# CITY OF PORTLAND, MAINE

**Project Name:** “118 on Munjoy Hill” Condominium  
12 unit residential, and 2 unit commercial, condominium  
**Project ID:** #2013-255  
**Project Address:** 118 Congress Street  
**CBL:** 16-D-2  
**Applicant:** Ed Theriault, EMT, LLC (118 Condominiums, LLC)  
**Planner:** Jean Fraser

On January 28<sup>th</sup>, 2014 the Portland Planning Board considered and approved a Level III Final Site Plan and Subdivision proposal for the construction of a 4-story 14 unit condominium building at 118 Congress Street, comprising 2 commercial units totaling approximately 1800sq ft floor area, 18 parking spaces on the ground floor to the rear of the commercial units, and 12 residential units above.

1 NORTH ELEVATION
1/8" = 1'-0"

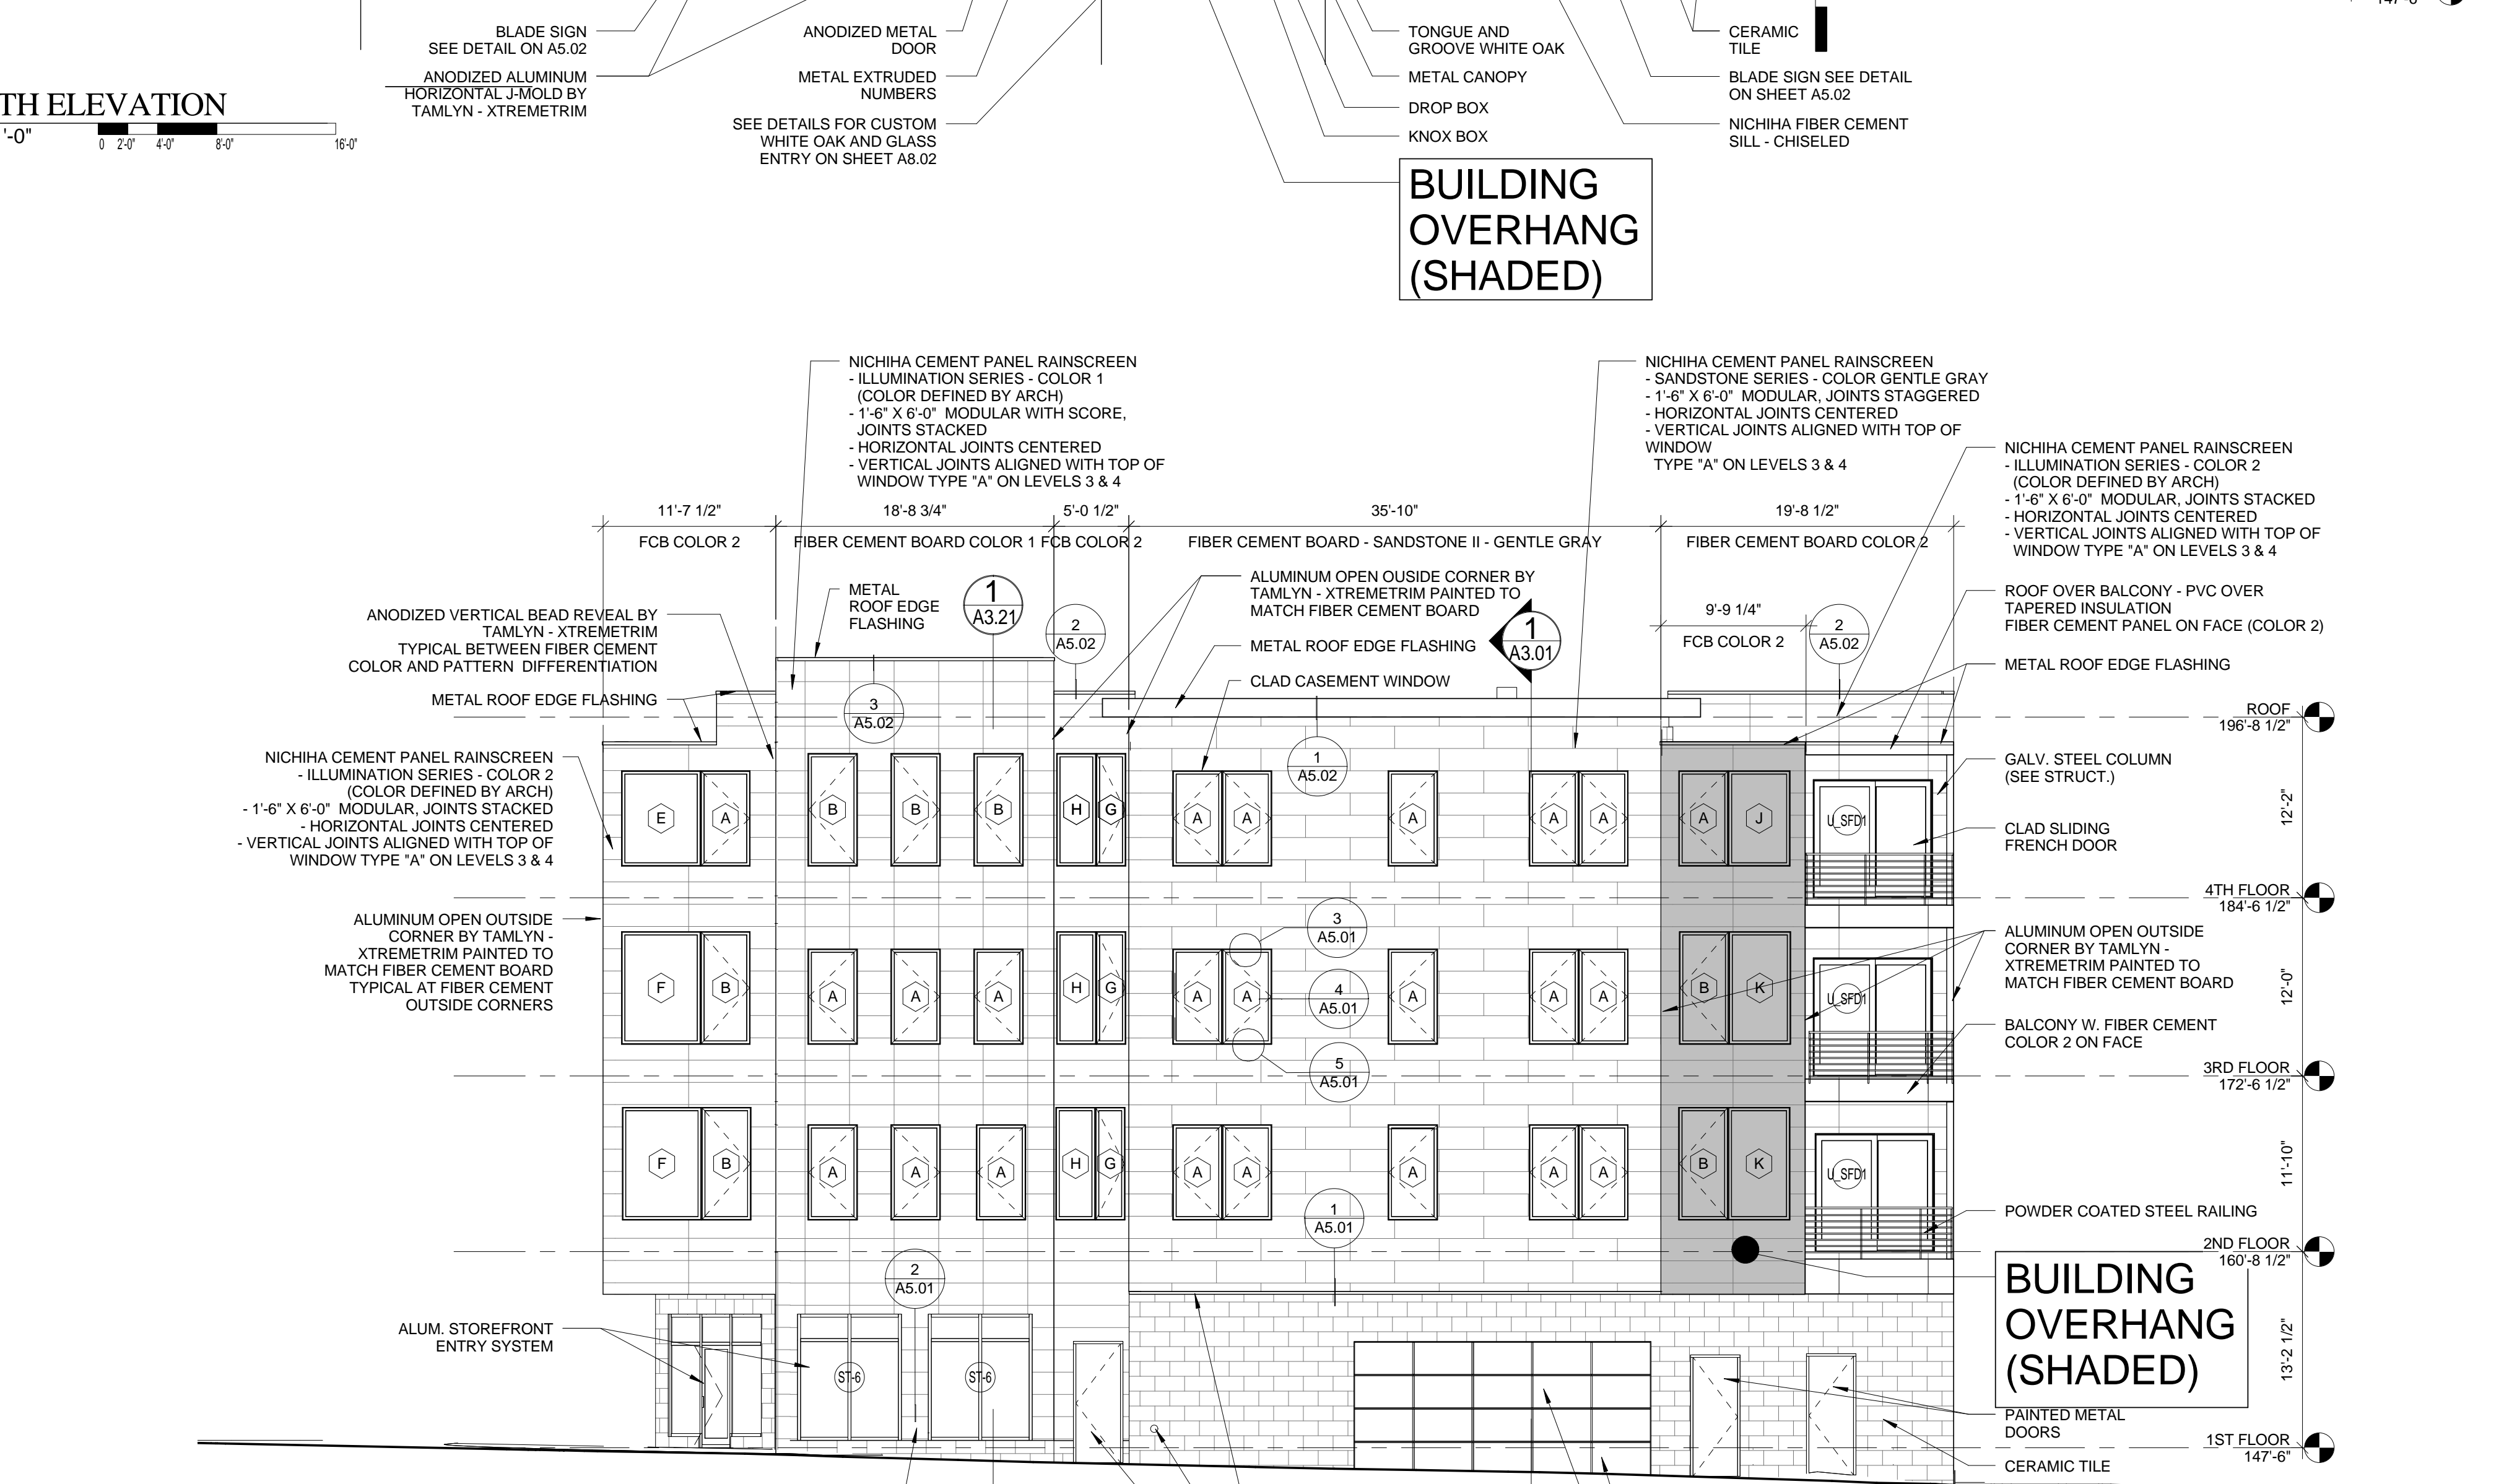
- i. The applicant shall submit a revised building design that results in the decks on St Lawrence Street being within the property boundaries while maintaining the current quality of design in regards to facade articulation and variation of form, for review and approval by the Planning Authority prior to signing of the Subdivision Plat; and

The Planning Board, in considering this project, were aware that the associated building projections (including decks) over the ROW would need a license to be approved by the City Council and that there were staff concerns about this aspect of the project. The Planning Board voted 5-2 (Dean and Hall opposed) to send a Communication to the City Council outlining the basis of the Board's support for the projections on this particular project.

EROSION CONTROL PLAN

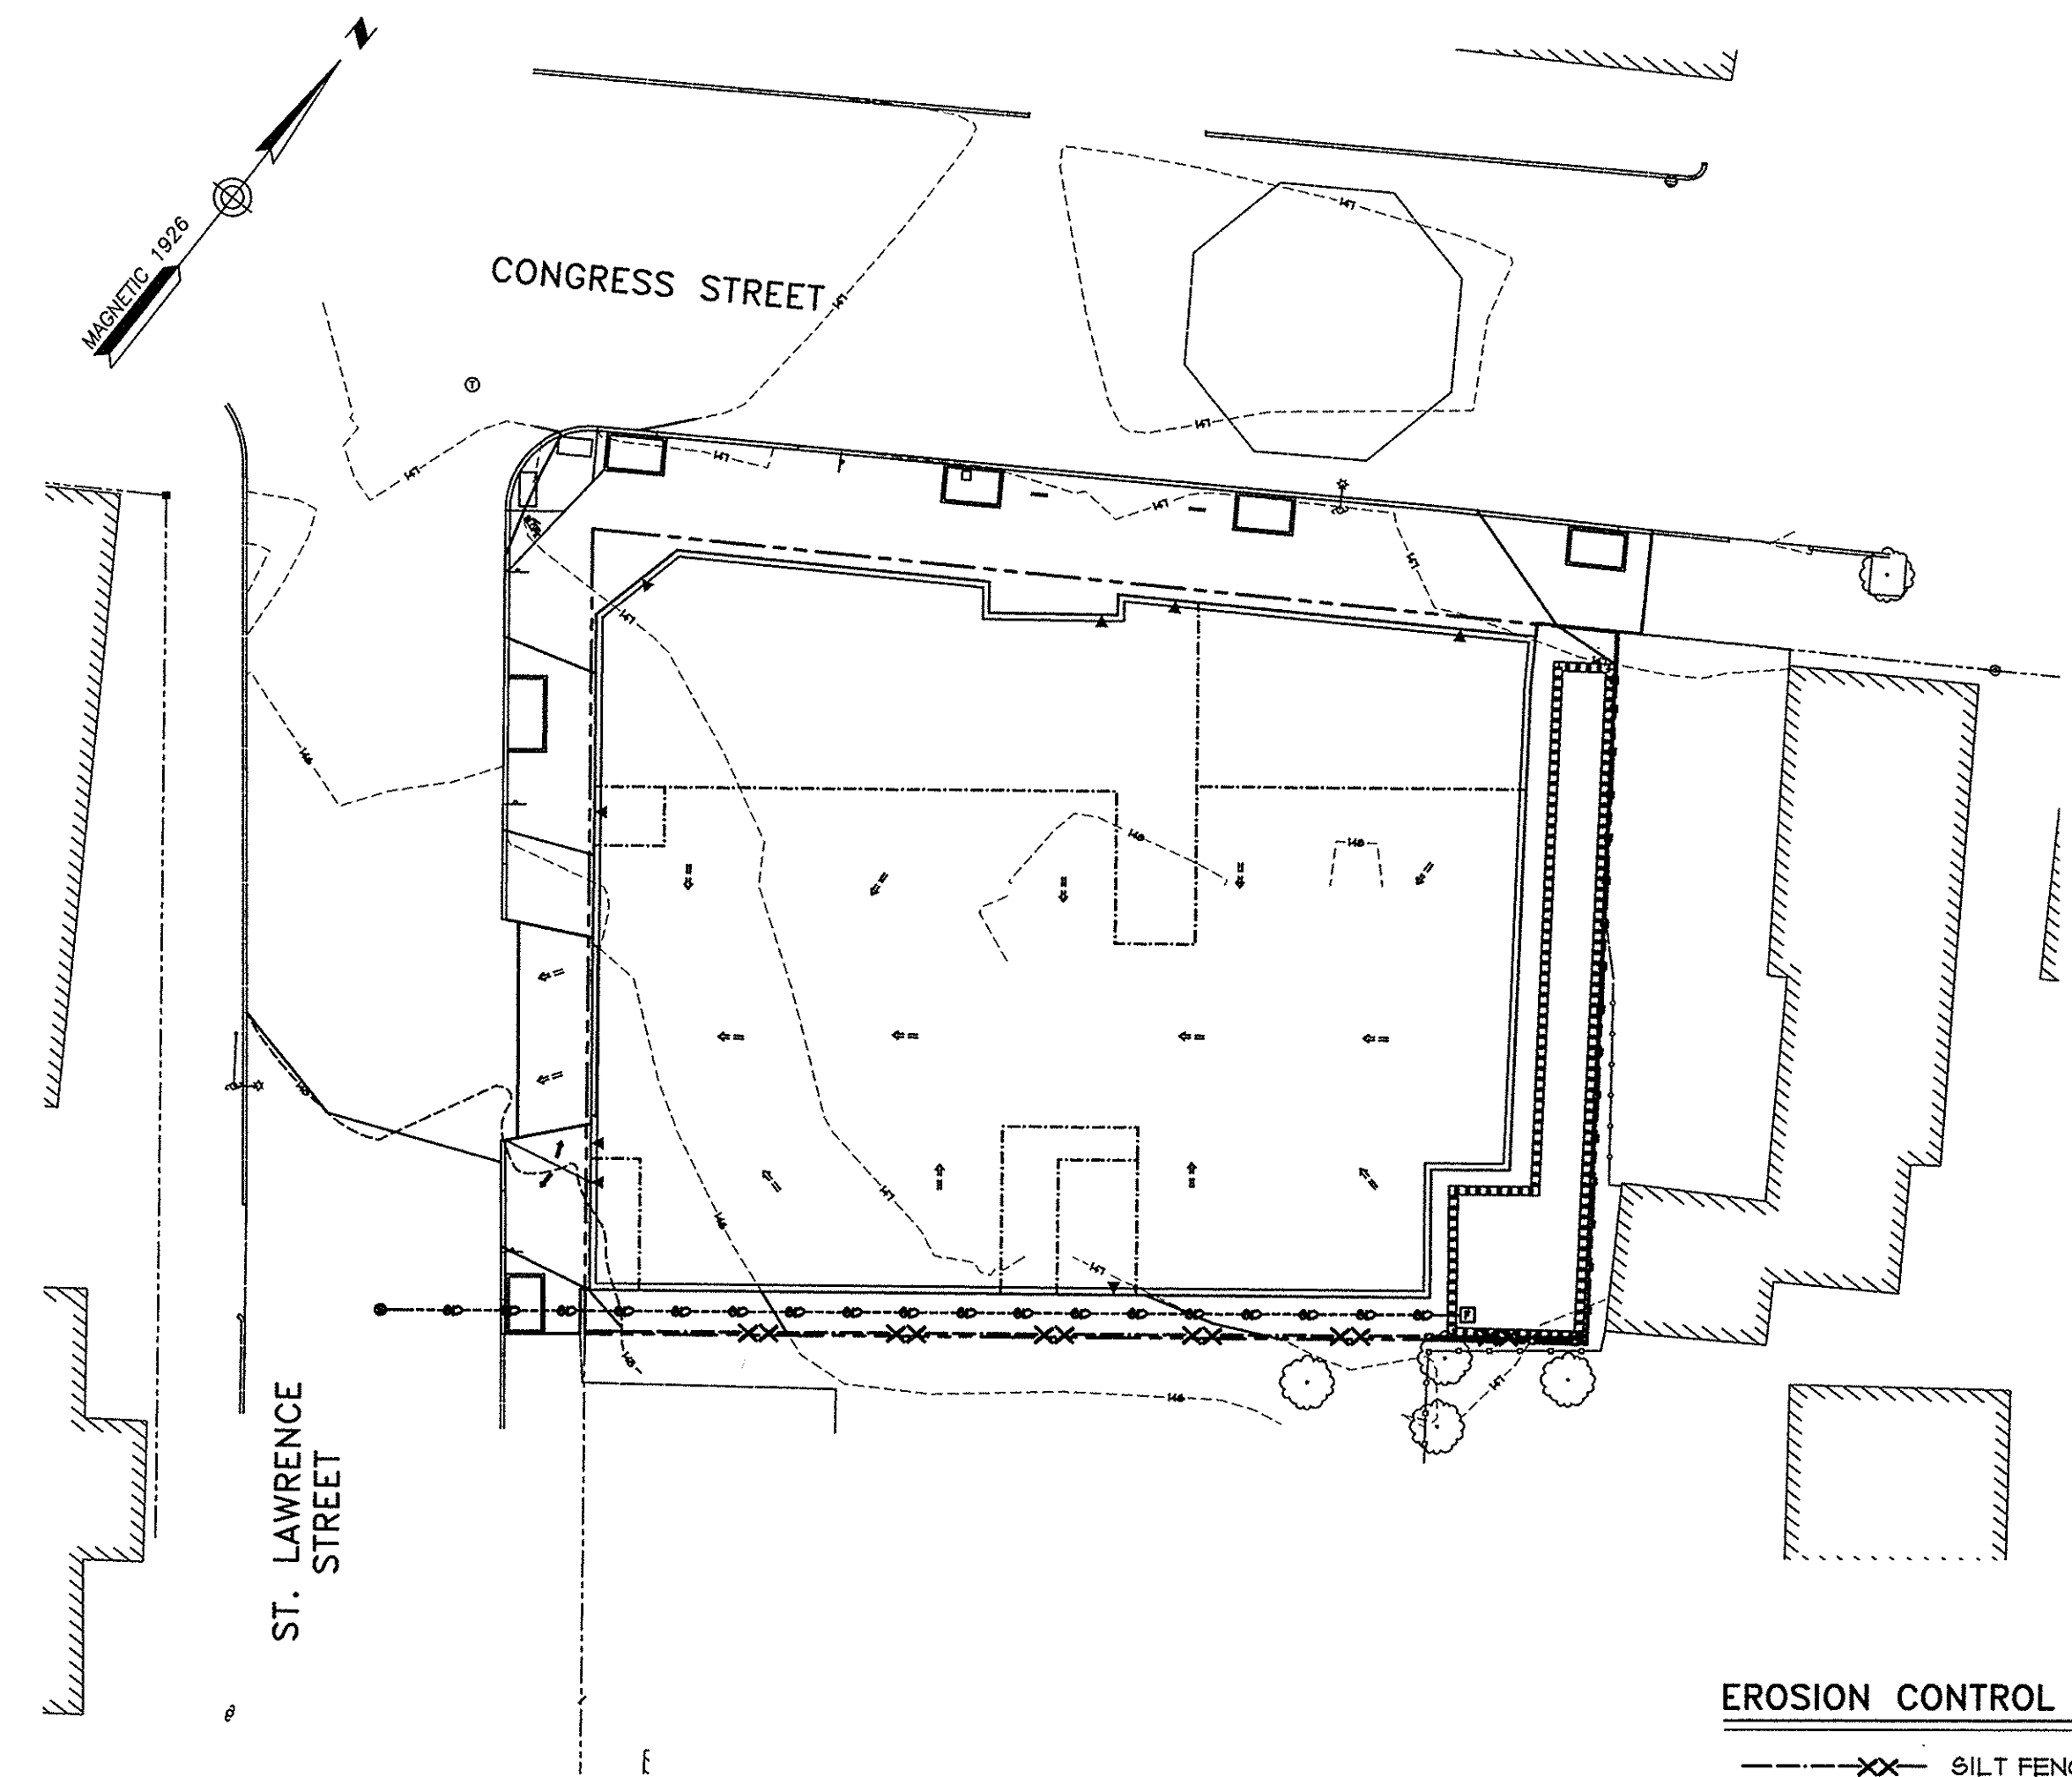
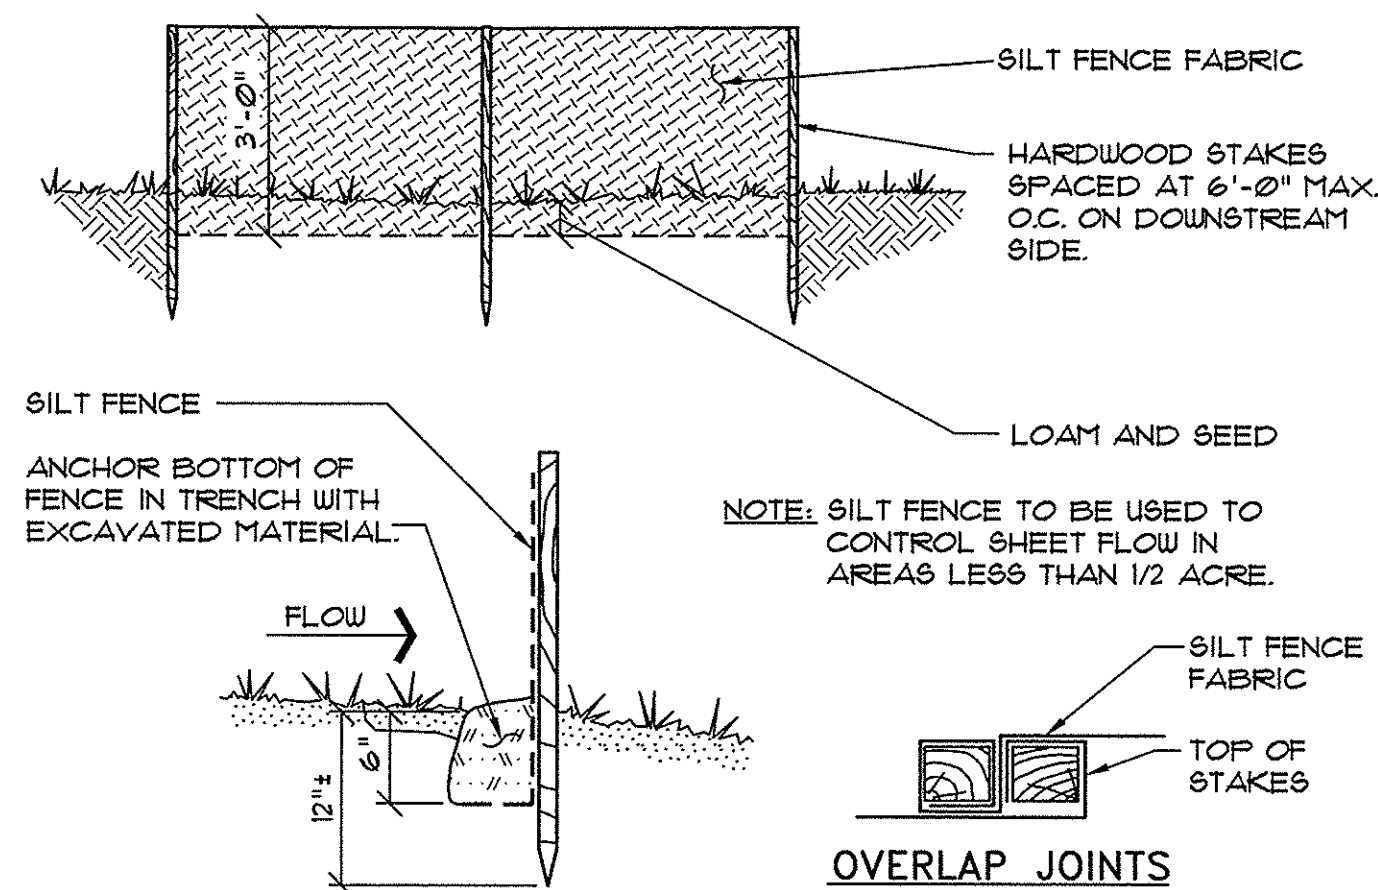
- 2) The Applicant has provided a plan, notes, and details to address erosion and sediment control requirements, inspection and maintenance requirements, and good housekeeping practices in general accordance with Appendix A, B, & C of MaineDEP Chapter 500. The plan should also include a note stating that the street Right-of-Way shall be kept clean from dust, tracked soil/mud, and construction debris and swept as necessary or as requested by the City of Portland to minimize dust and sediment originating from the site.
